**From:** Wakefield, Nick <nick.wakefield@environment-agency.gov.uk>  
**Sent:** 23 September 2019 17:13  
**To:** West Burton C <WestBurtonC@planninginspectorate.gov.uk>; Jones, Hefin <HEFIN.JONES@planninginspectorate.gov.uk>  
**Cc:** Patterson, Jeremy <Jeremy.Patterson@environment-agency.gov.uk>; Blackeby, Eleanor <eleanor.Blackeby@environment-agency.gov.uk>; Smith, Heather <heather.smith@environment-agency.gov.uk>  
**Subject:** EN010088 WEST BURTON C (GAS FIRED GENERATING STATION) - Environment Agency's Relevant Representations.

**Our ref:** LT/2019/124504/01-L02  
**Your ref:** EN010088  
**Date:** 18 September 2019

**WEST BURTON C (GAS FIRED GENERATING STATION)  
WEST BURTON POWER STATION SITE**

Figure 3: Site Boundary (Order Limits) and indicative site layout

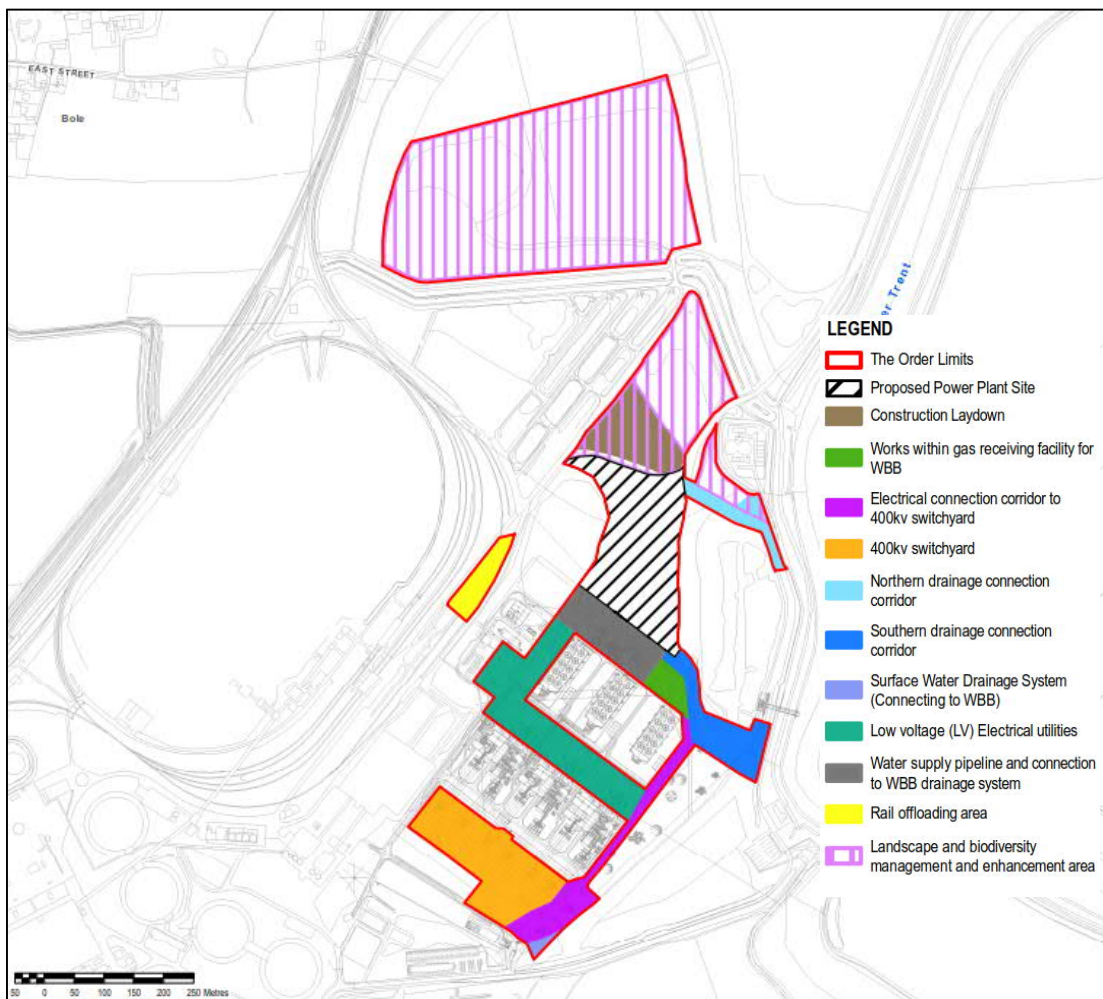
It is noted that the area identified as the construction laydown area partially lies within flood zone 2. However, given that a very small area within the north western section of the lay down area is affected by flood zone 2 and that the area in question is far in excess of 16 metres away from the Environment Agency maintained flood defences, a FRAP would not be required in this instance.

Figure 4: Environment Agency Flood Zones and Site Boundary

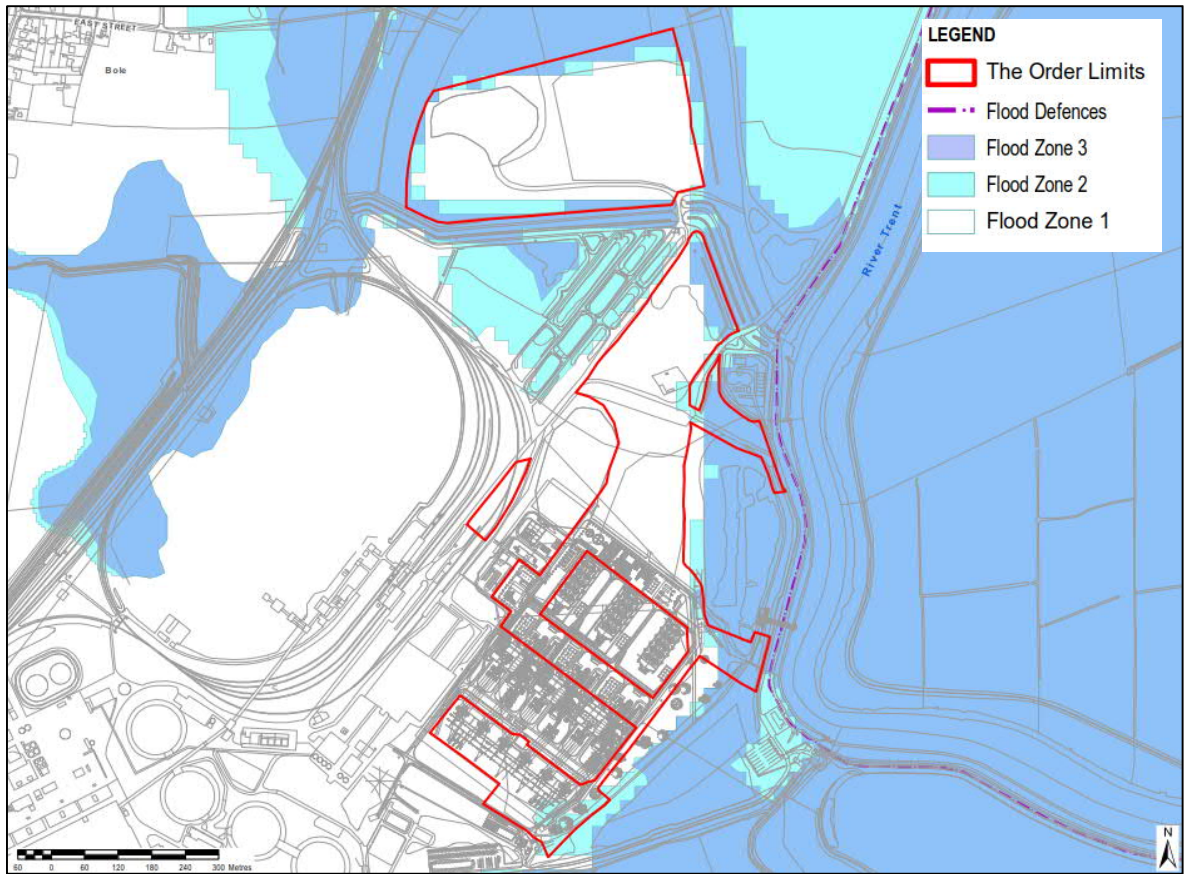
. The FRA has indicated that the northern and southern outfall corridors are within flood zone 2 and 3. Neither outfall corridor has been assessed as part of the FRA. Therefore if either or both of the outfall corridors need to be constructed then the FRA will need to be updated and resubmitted for review.
